Recommendation Report

Application No. BR/62/13/A

2 No back illuminated fascia signs and 1 No internally illuminated projecting sign to front elevation.

43-45 Queensway Bognor Regis

PROPOSED FRONT ELEVATION.

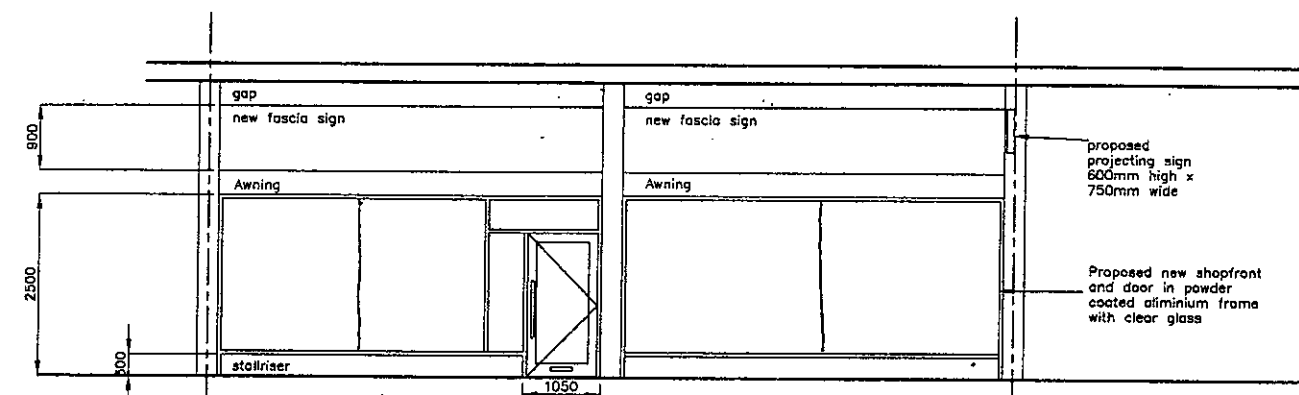
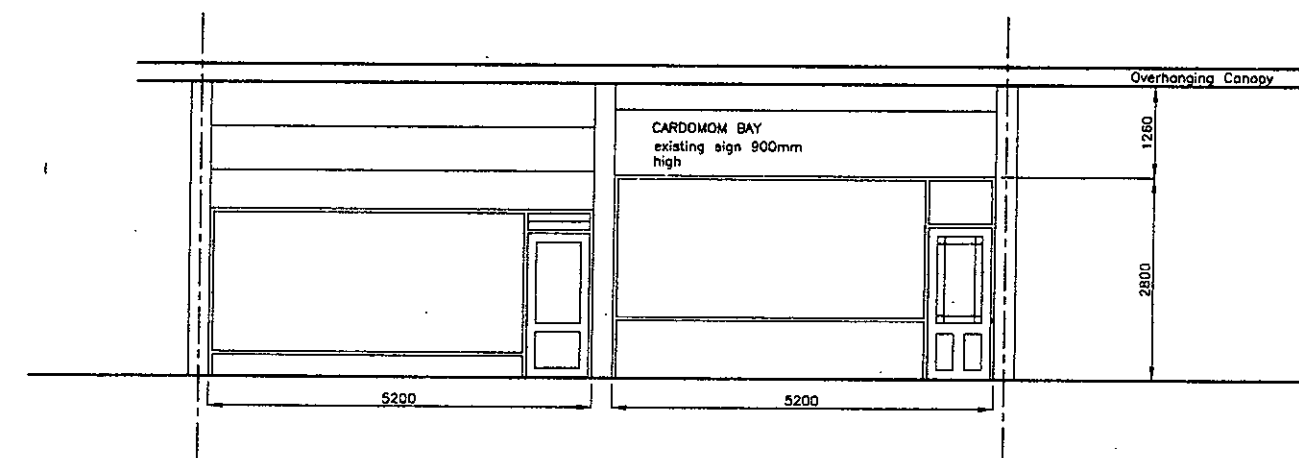
Please could you colour the proposed fascia sign and projecting sign, and send the elevation for my attention.

FASCIA SIGN 1:50

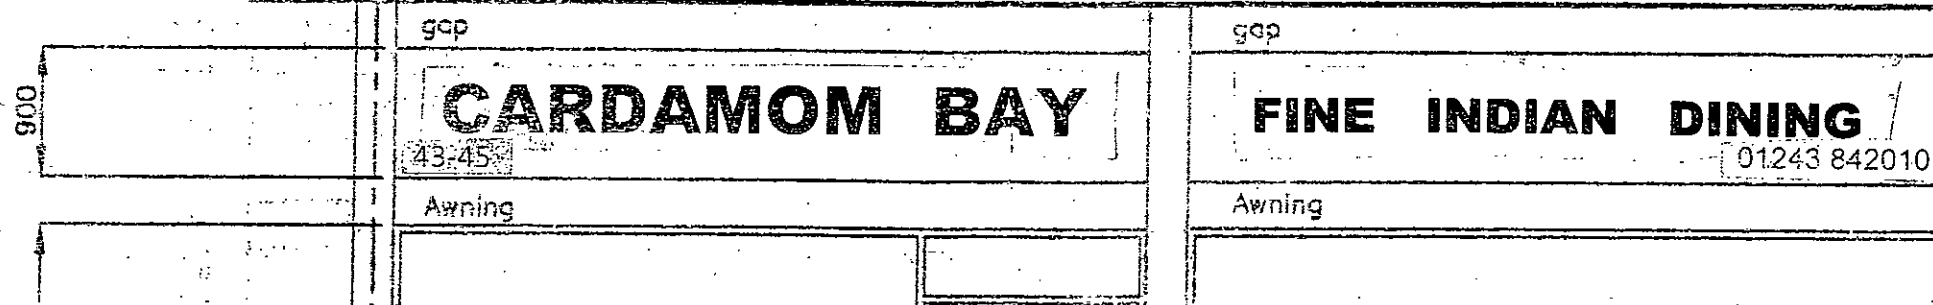
Please could you colour the proposed fascia sign and projecting sign, and send the elevation for my attention.

(color scheme for signage? - need color plan)

Please find attached coloured visual of fascia and projection signage as requested.

RAL 8029 for the brown and Ral 1004 For the gold.
